As requested, I attach the latest drainage maintenance plan addressing the risks identified by Laura.

Thank you for providing the details, I have the following comments:

Subject: RE: LU/330/18/PPL – Land at Cornfield Close, Littlehampton

SOAKAWAY CONSTRUCTION SEQUENCE

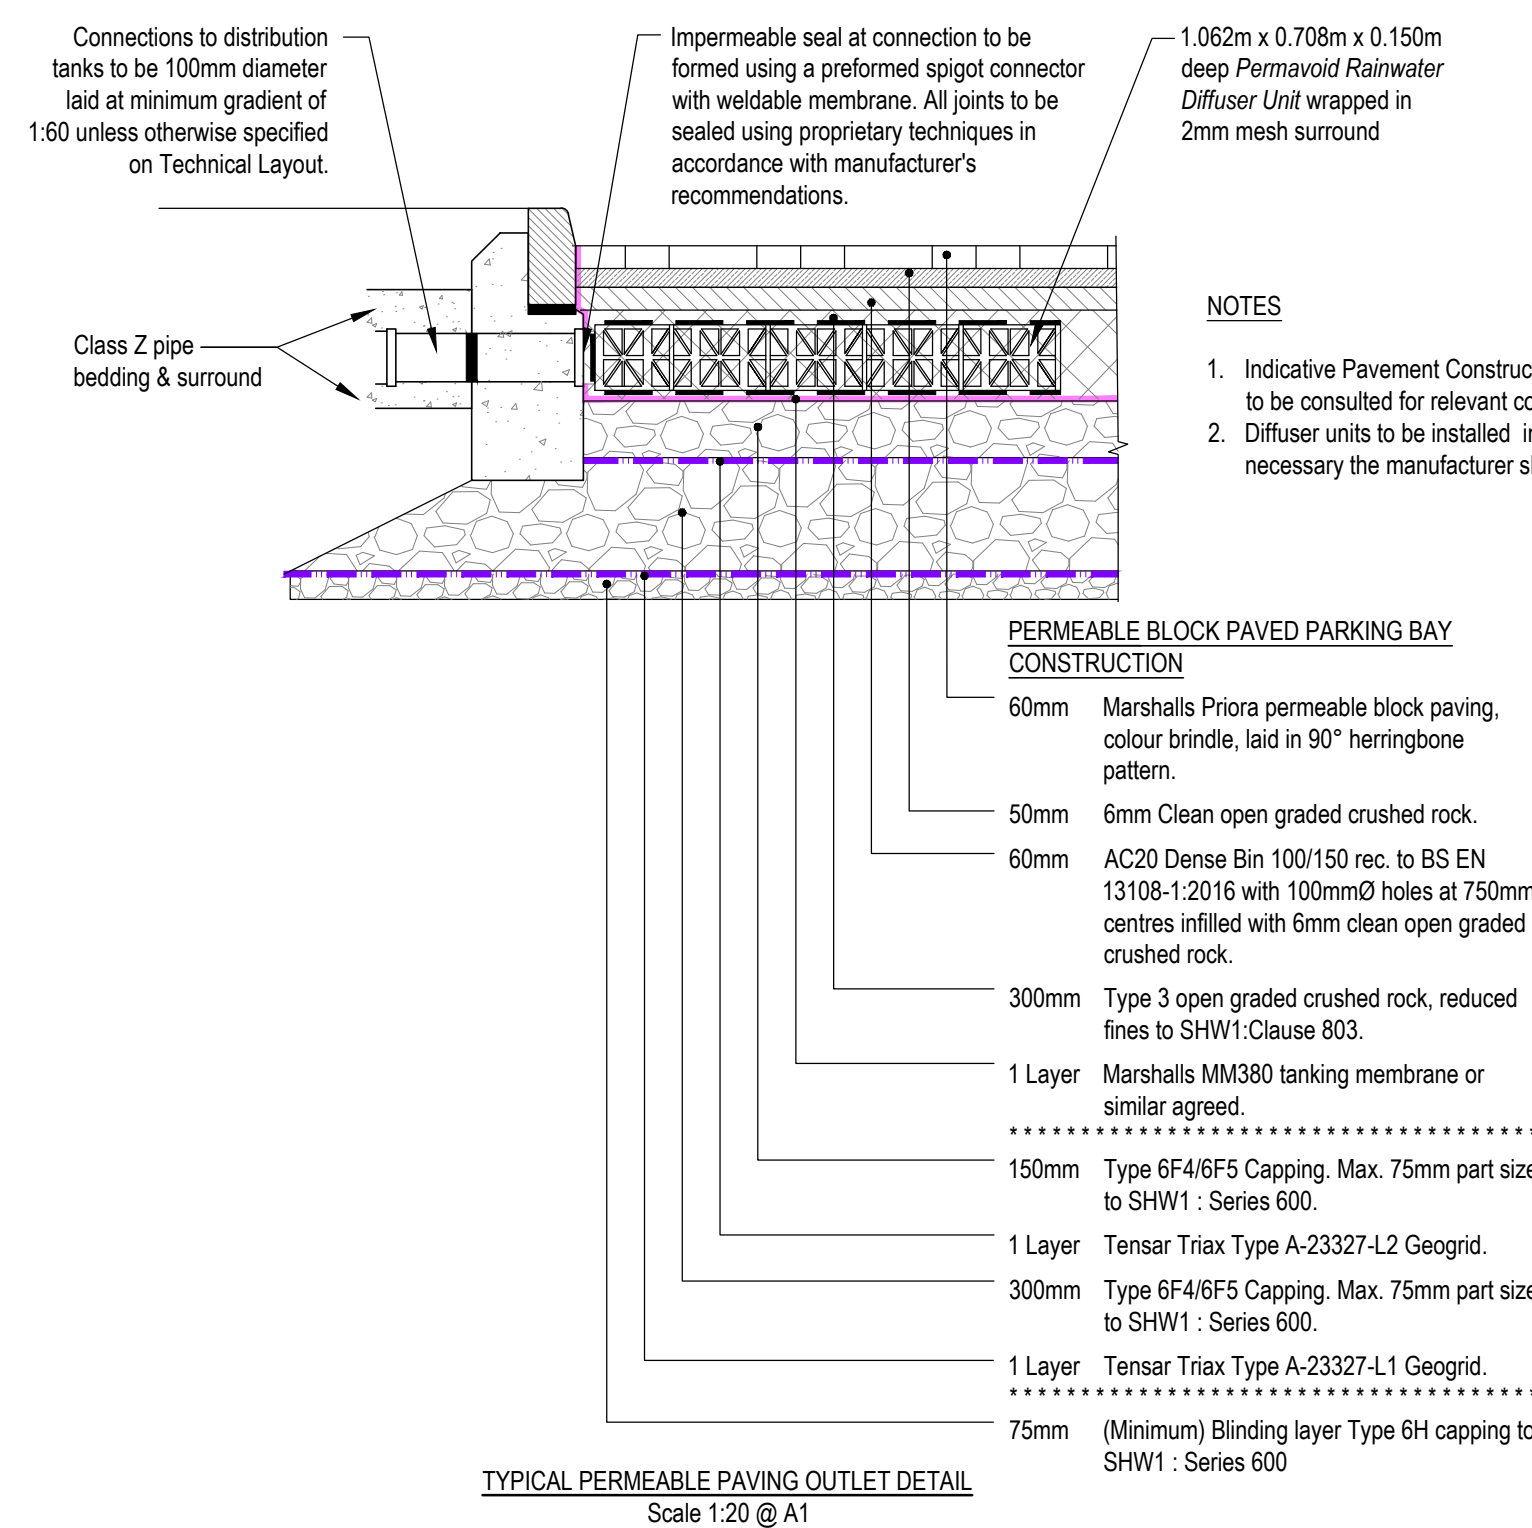
8. Please provide a construction detail drawing of the lower crate access.

This has been added to Drainage Details Sheet 2 M637_15.005. On review, please consider the safety of access/ maintenance and consider if a standard inspection chamber (no catchpit) could provide a means of maintenance for the majority of occasions without having to send a man down the inspection chamber.

Noted. Chamber S50 has been amended to remove the sump – updated drawings are attached.
